**From:** planning  
**Subject:** FW: app3/2016/0177 Higher Boyce Farm

**From:** Bloomer, David [<mailto:David.Bloomer@lancashire.gov.uk>]  
**Sent:** 08 March 2016 09:41  
**To:** Stephen Kilmartin  
**Cc:** LHS Customer Service; planning  
**Subject:** app3/2016/0177 Higher Boyce Farm

### **Highway comments on application 3/2015/0961**

**Proposed Site Plan**  
Scale 1:100

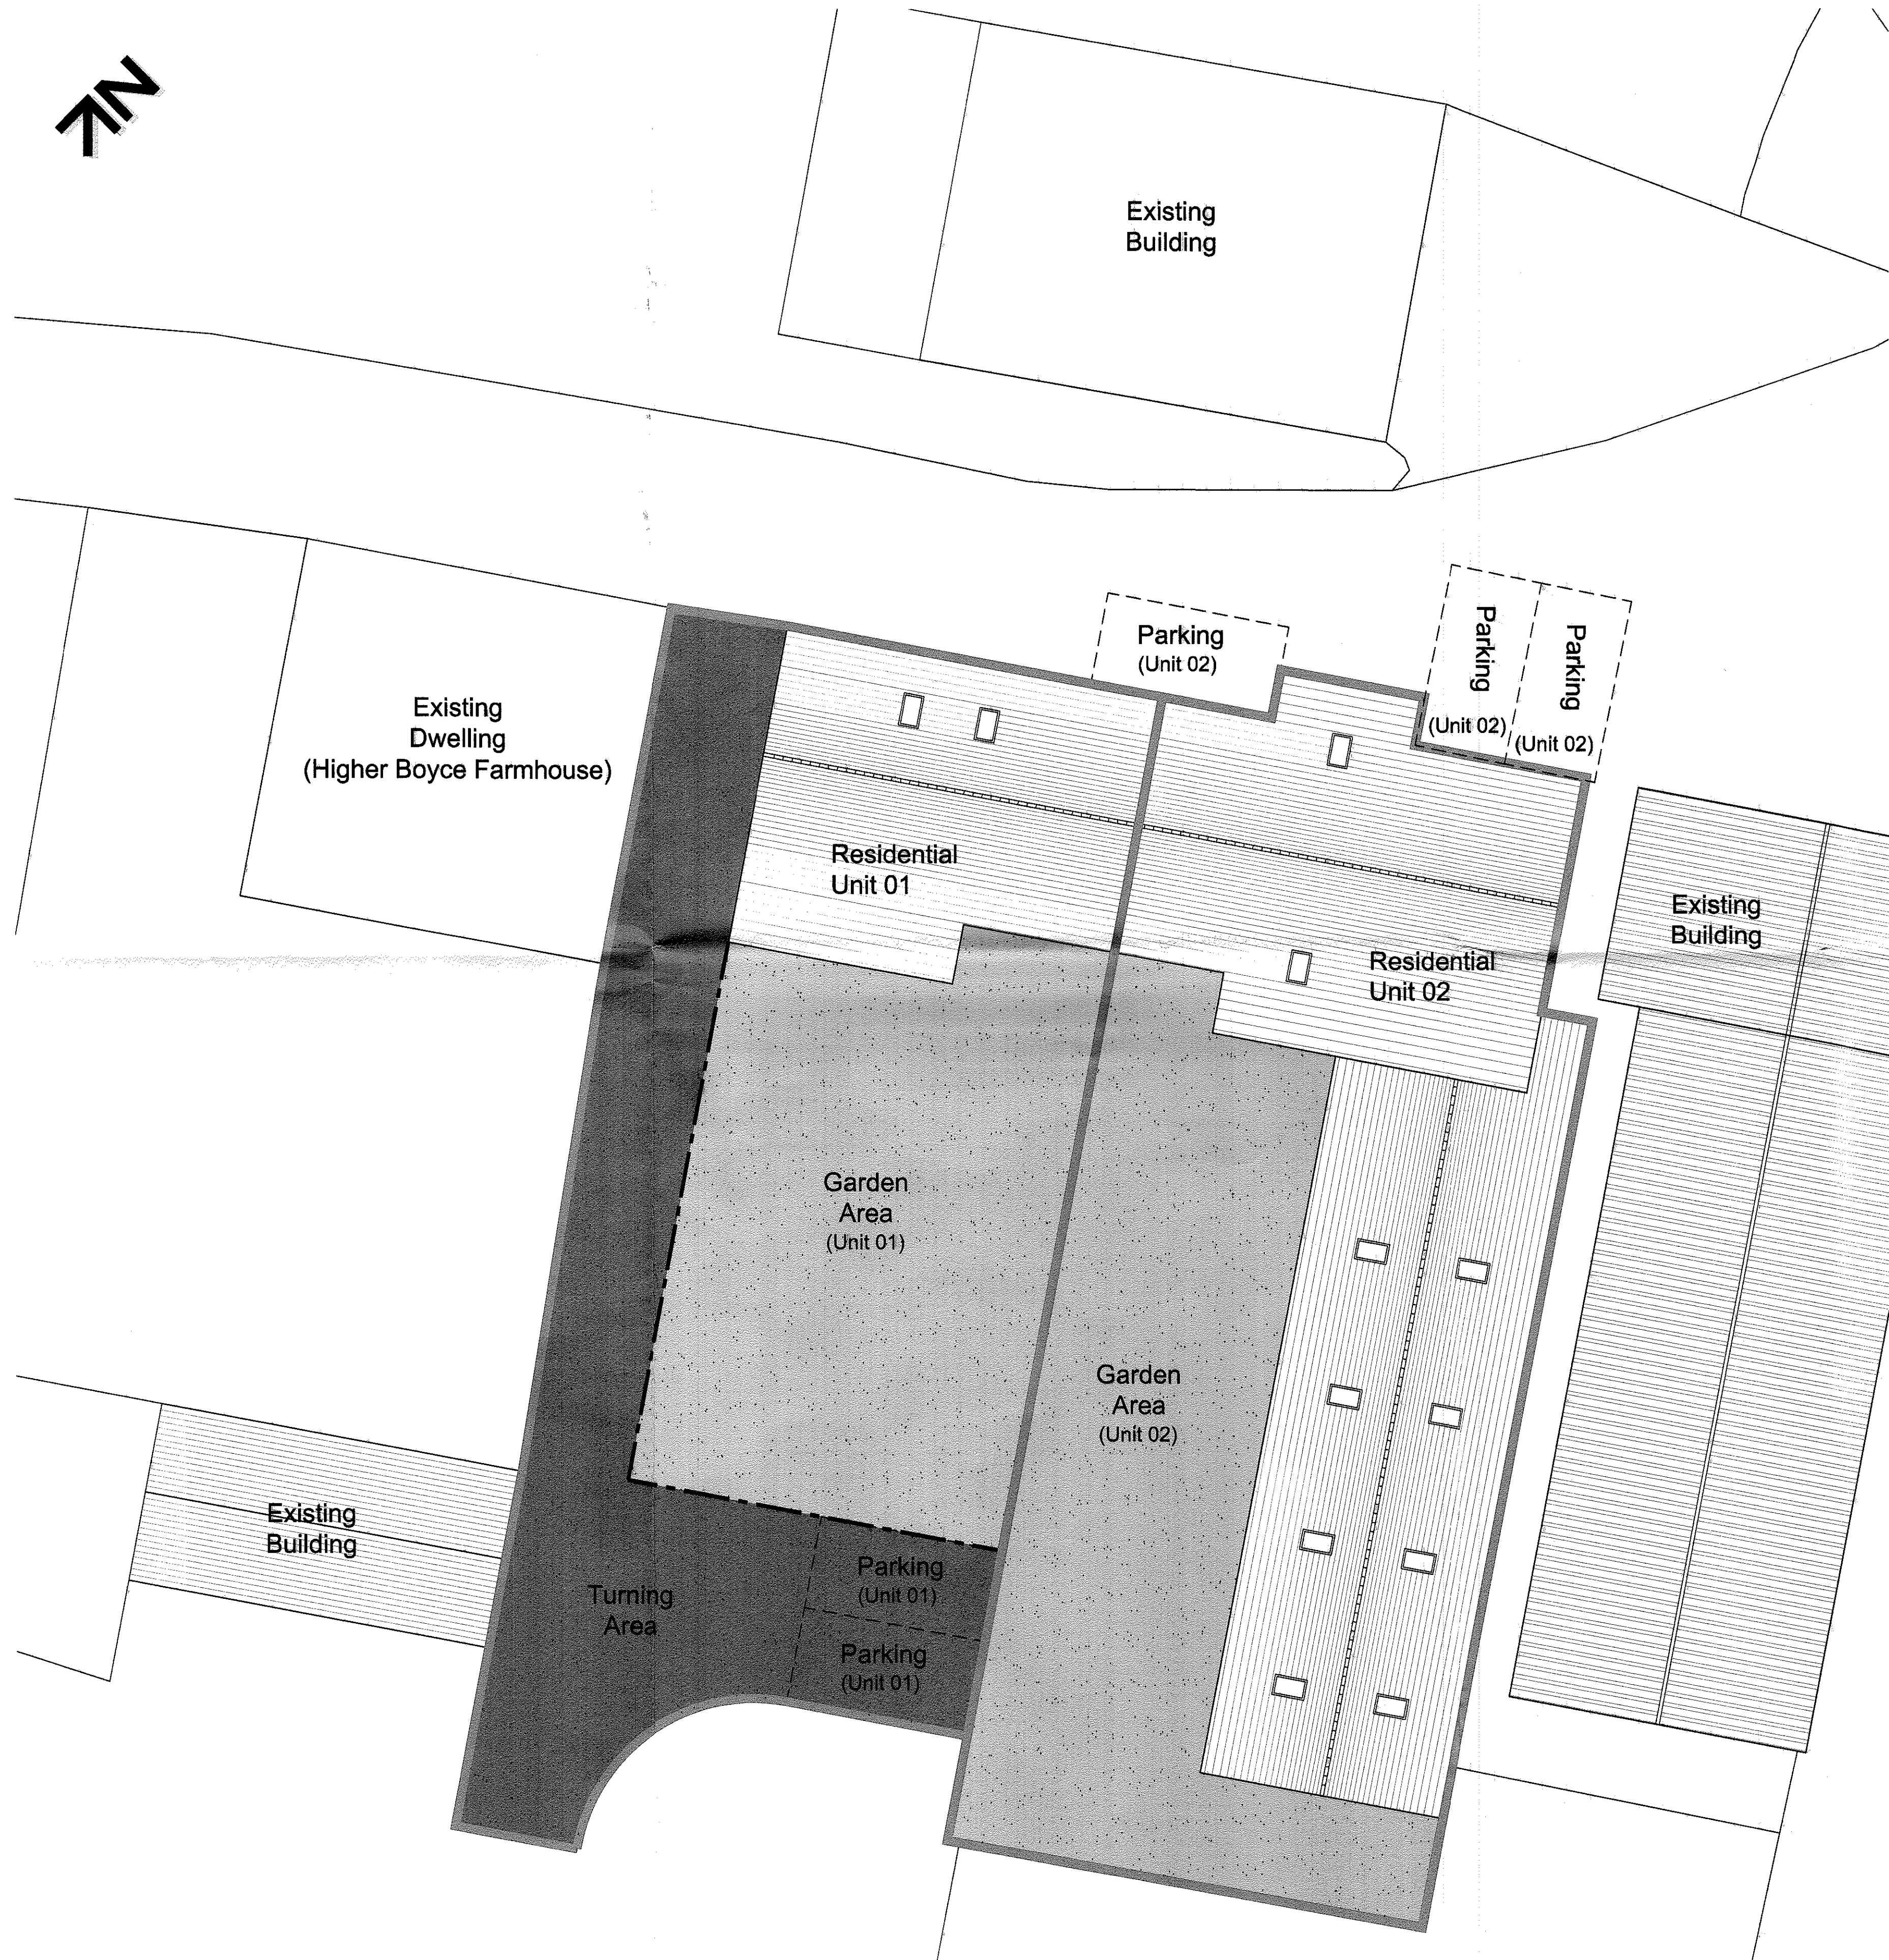
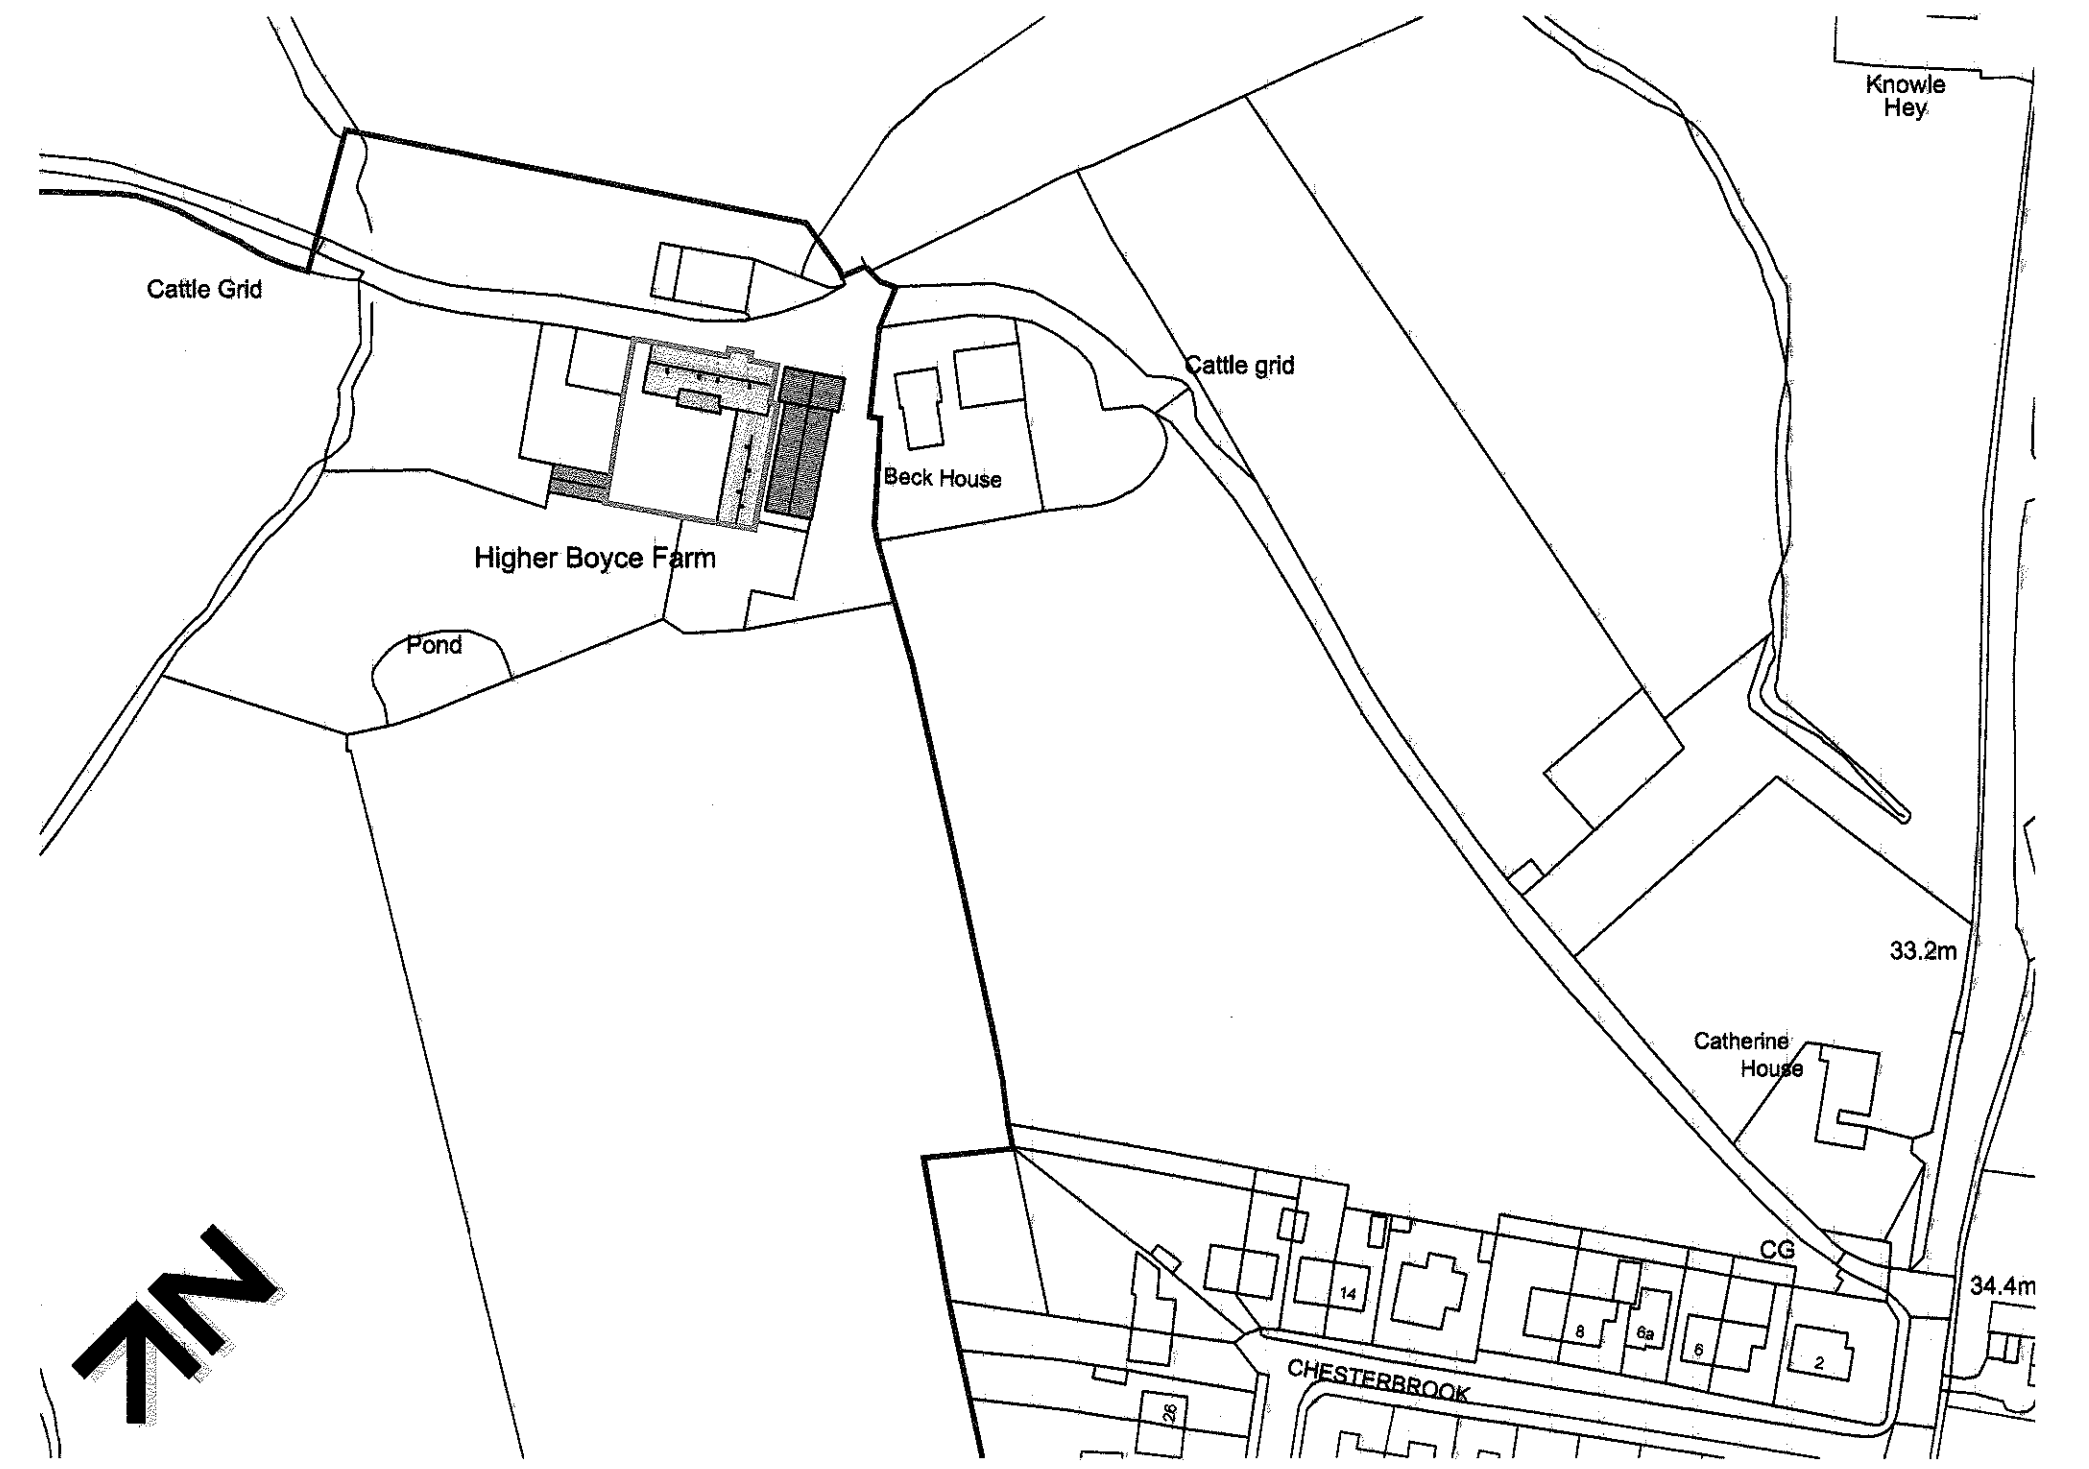
the proposal will increase the number of trips to and from the site,. Currently there is a single track lane extending from Stoney Gate Lane to the site which also serves as a public right of way. Due to the anticipated increase in vehicle movements I would want to see the access between Stoney Gate lane between the access and The cattle grid widened to 6.0m to allow opposing vehicles to pass and the creation of a passing place suitable to accommodate a tractor and trailer on the south westerly side of the track in the vicinity of the "summerhouse" in the garden of Catherine House.

- a) The parking for unit 1 is unlikely to prove attractive to the residents due to distance from the dwelling with the likelihood of parking occurring in the access with vehicles reversing out onto the public footpath. A more suitable option would be to bring the parking provision closer to the dwelling and use proposed access as a turning head.
- b) The 2 parking for unit 2 projects into the access to the existing farmhouse access road and partially obstructs the public footpath. In addition the reversing area would appear to be outside the control of the residents and may on occasion be obstructed. The single space does not have any identified area for the vehicle to turn around which would result in vehicles reversing along the public footpath.
